Appeal Decision

Appeal Ref: 6005592

4 Almond Avenue, Ickenham UB10 8NA

- The appeal is made under section 78 of the Town and Country Planning Act 1990 (as amended) against a refusal to grant planning permission.
 - The appeal is made by Mr/Mrs Sabharwal against the decision of the Council of the London Borough of Hillingdon.
 - The application Ref is 61421/APP/2025/2697.
 - The development proposed is a single storey side and double storey rear extension as granted 61421/APP/2024/2854 and enlargement of loft space to form habitable accommodation.
-

**DRAWING TITLE**  
Elevations

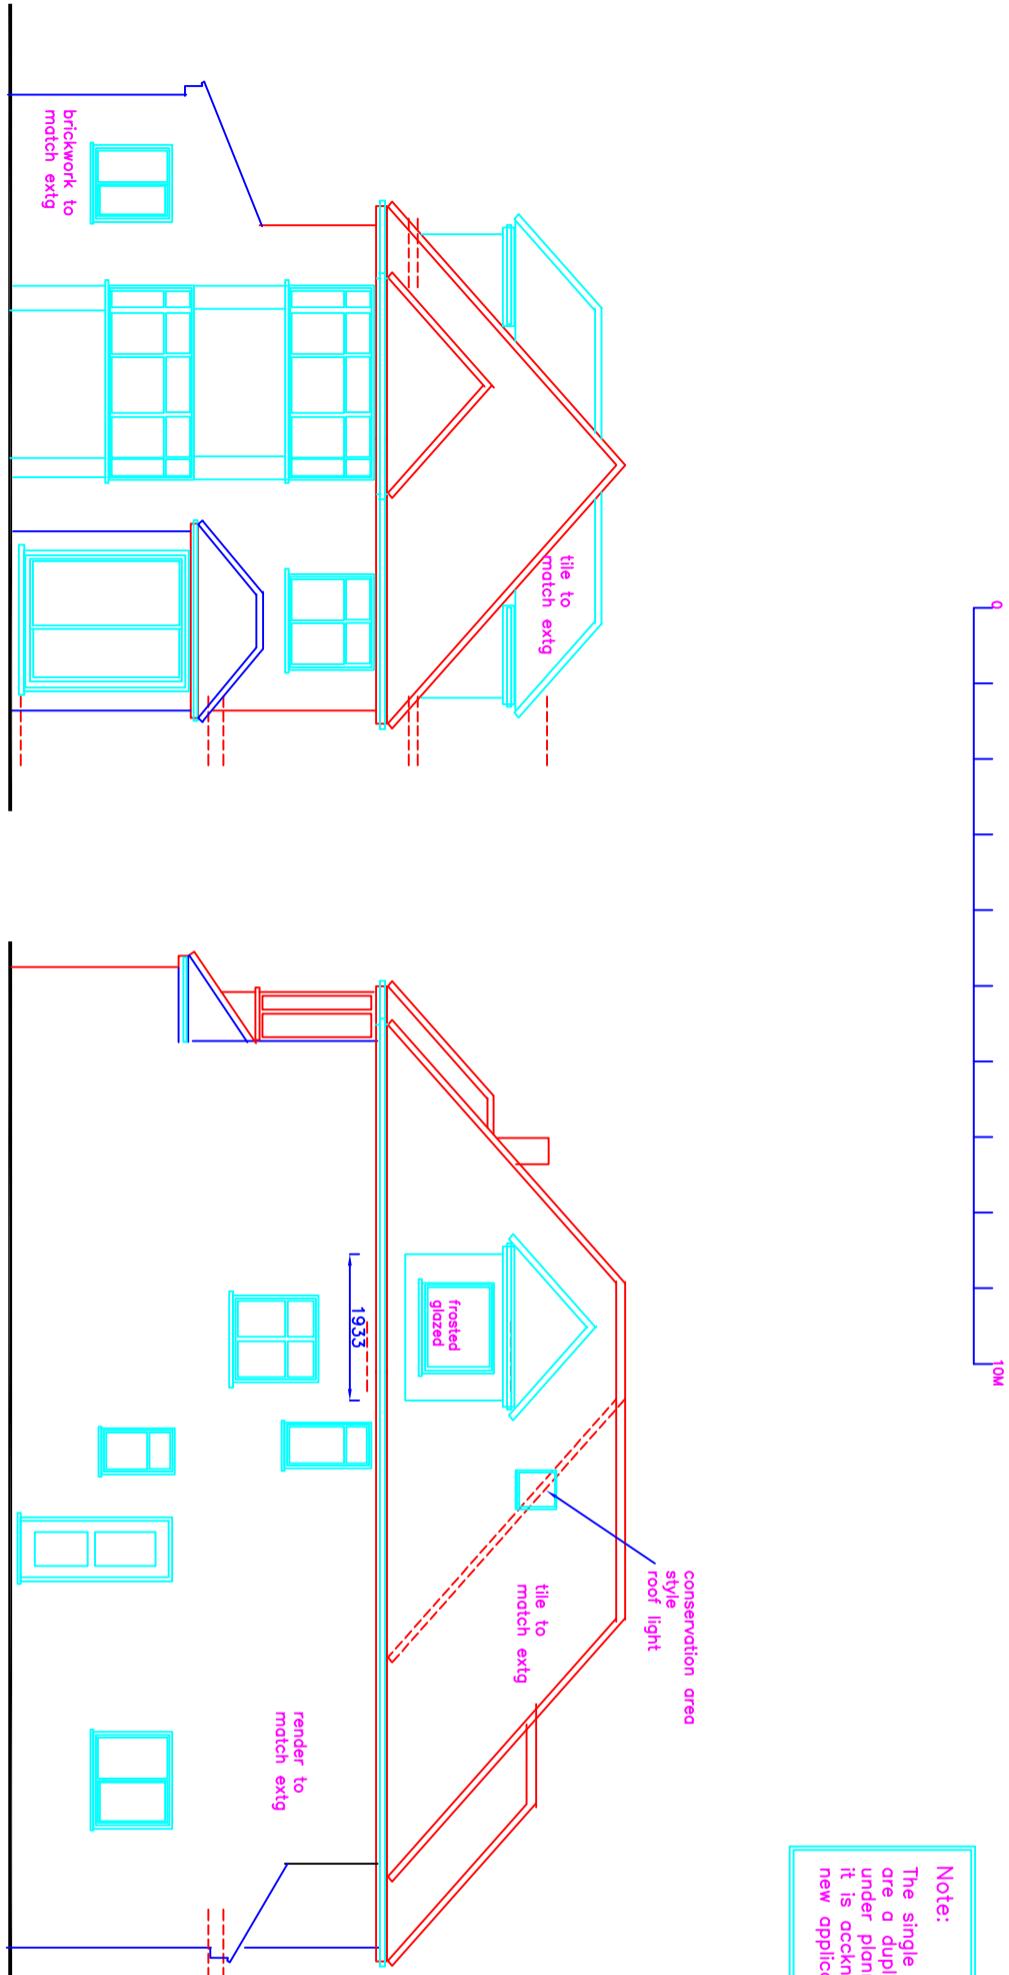
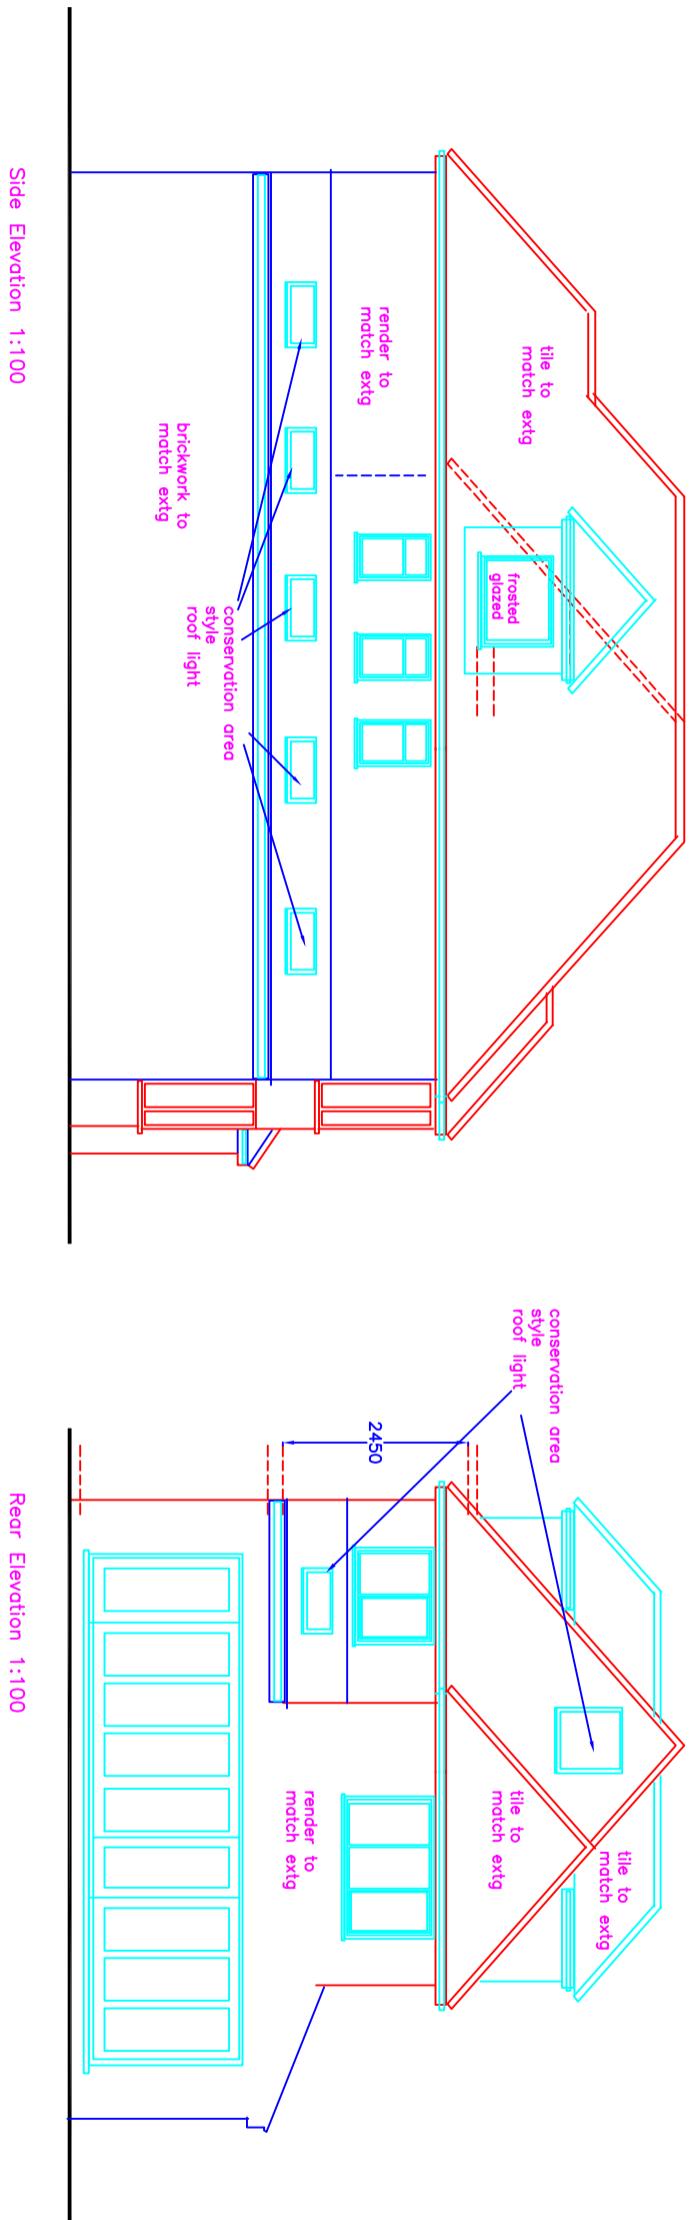
6. The proposal would see the side dormers set below the existing roofline and up from the eaves of the appeal dwelling, albeit only by a small amount. They would thus project almost the full depth of the roof, creating a significant increase in bulk at the upper level of the building. When viewed from the street, the resultant appearance would be that of a top-heavy and bulky roofline, out of keeping with the established, simple, and original lines of the street scene's roofscape.

7. The planning permission granted recently for Milton Court relates to a similar scheme as is considered under this appeal; in particular, my attention has been drawn to the approved side dormer window. However, the provided plans show that the dormer window is of a reduced scale when compared to that proposed at the appeal site. It is positioned lower on the roof, allowing a greater level of subserviency and does not project outwards to the extent that the appeal scheme would. My findings do not therefore change. Neither would they in light of the outcome of appeal APP/R5510/D/3270366, which did not include the proposed dormers subject of this appeal.
